Application No: R/113/21/PL
Site Address: 66 The Street Rustington BN16 3NR
Description of works: Construction of a single-storey upwards extension to provide an additional 4 No. residential units. This application affects the setting of a listed building & affects the character & appearance of the Rustington Conservation Area & is in CIL Zone 4 (Zero Rated) as flats.

Thank you for your internet representation made on 2nd June 2021 which has been recorded as an objection with the comments as follows:

GROUND FLOOR PLAN

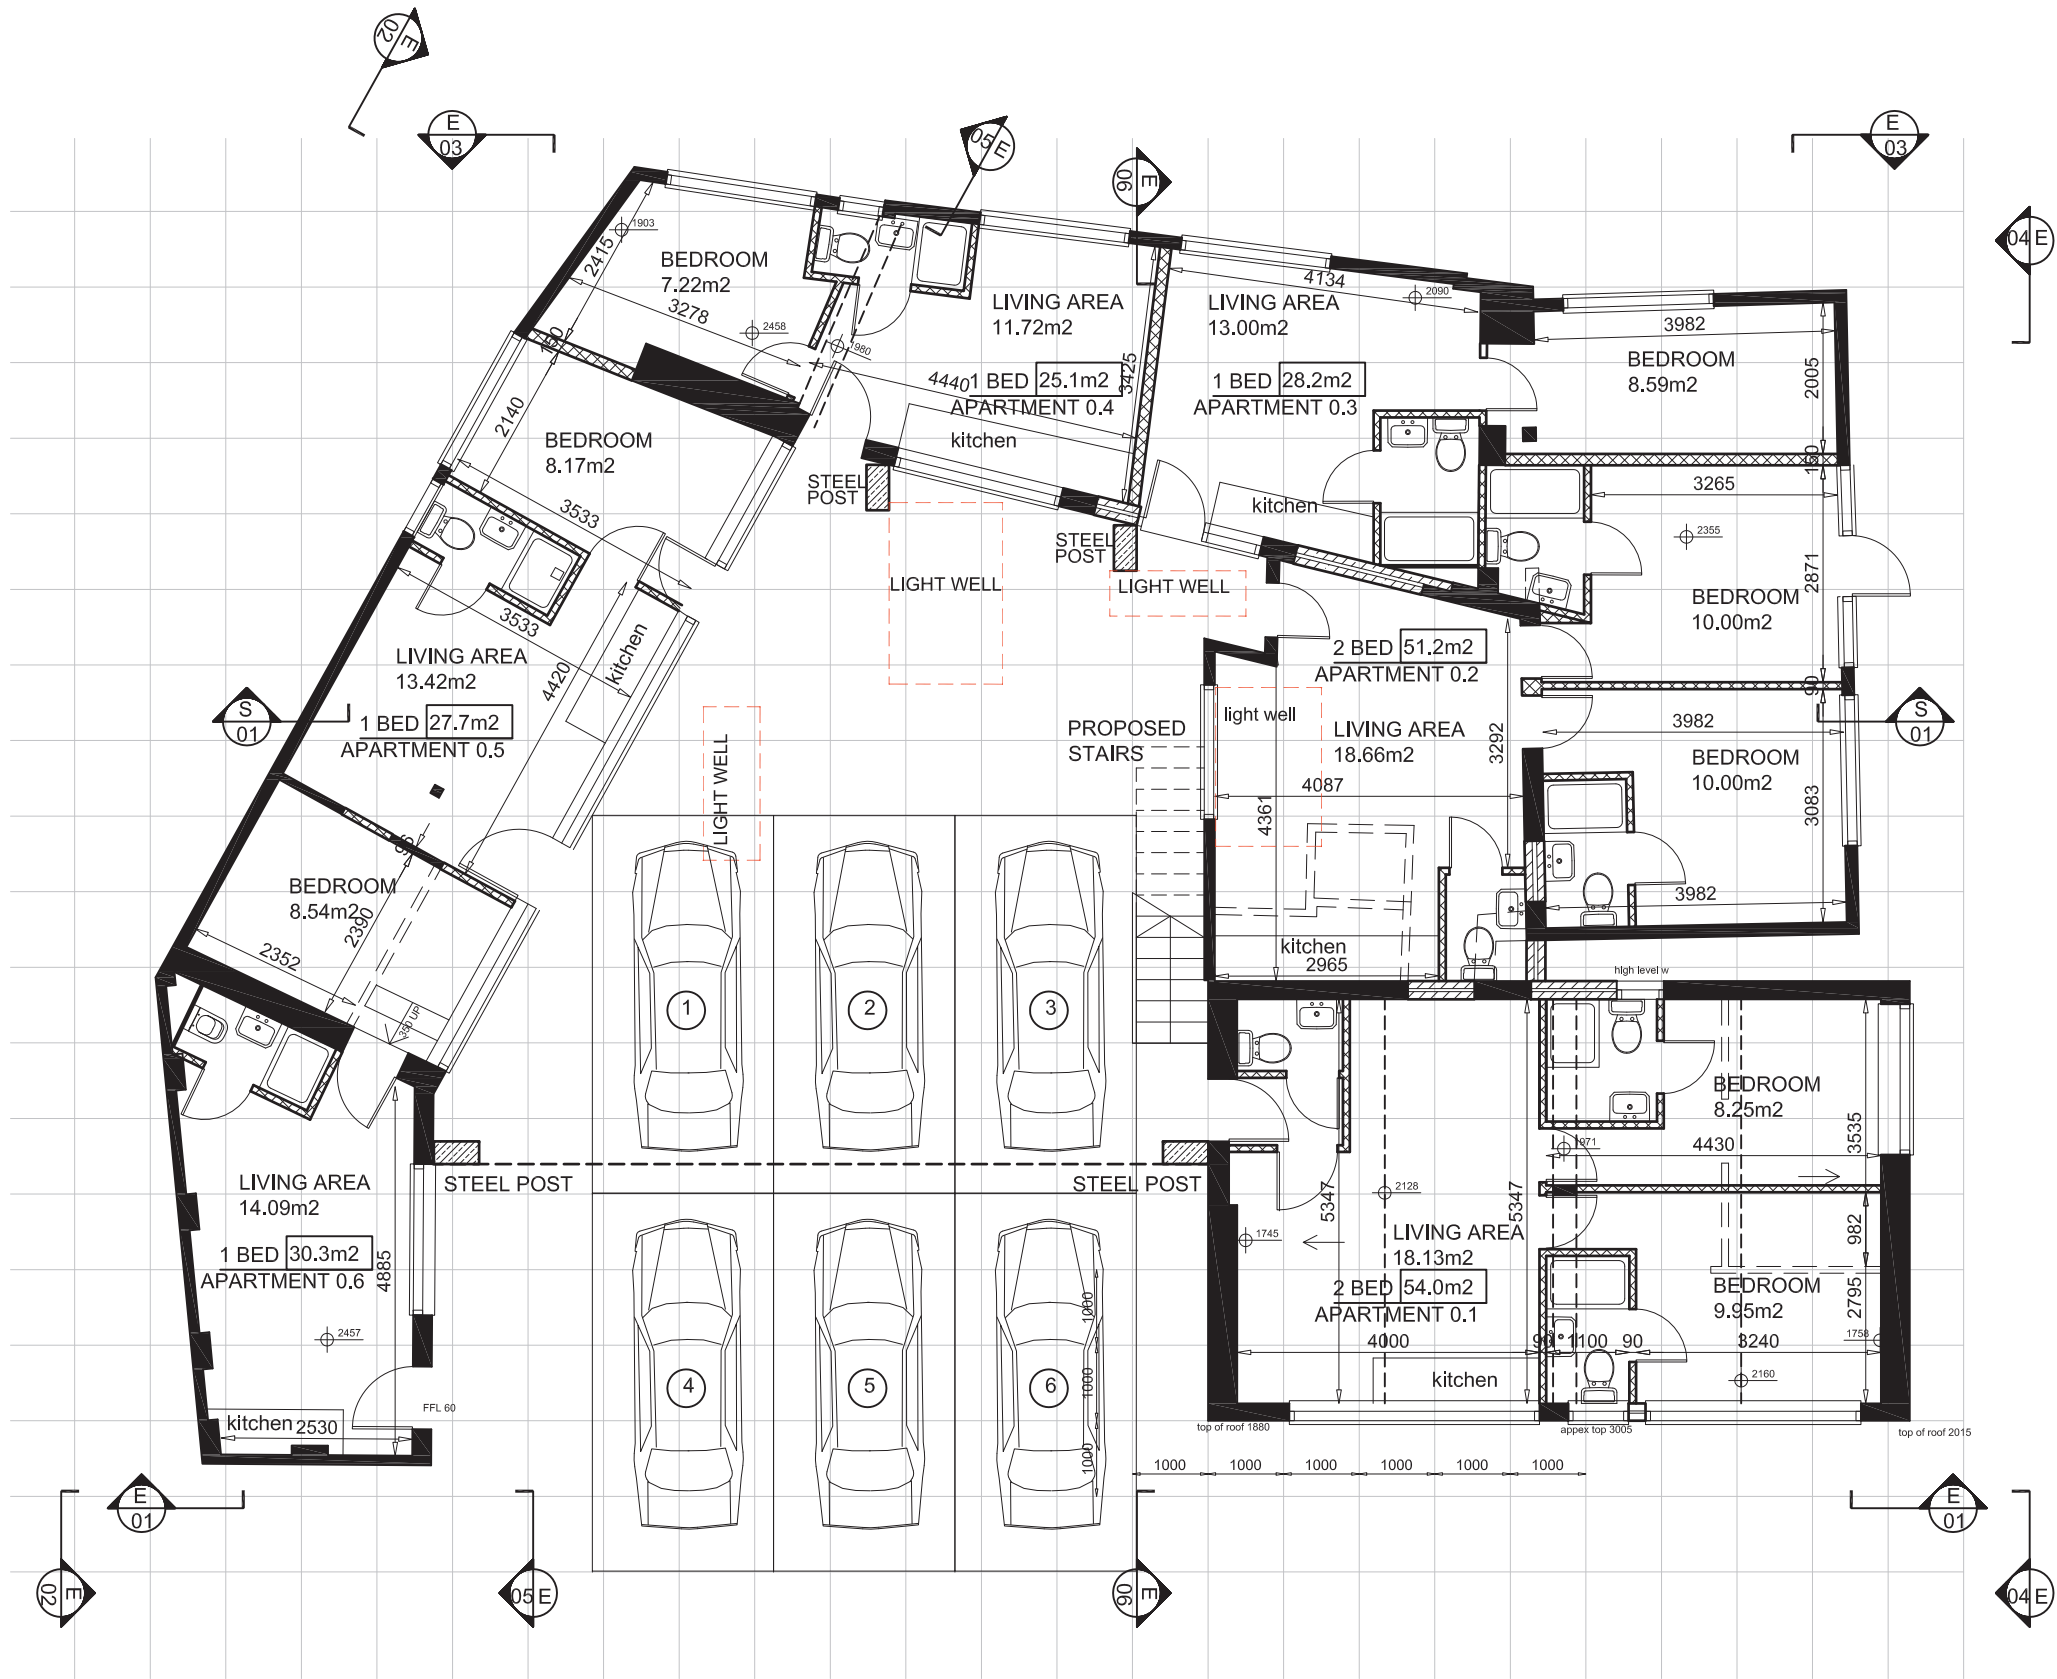
Lastly, it is ridiculous to think that 6 vehicles will park as proposed on the plans of the flats; it implies that 3 cars at the front spaces will need to move every time the rear spaces want access in and out. Common sense can see that that will not work and therefore on street and side road parking will be encouraged as a result.
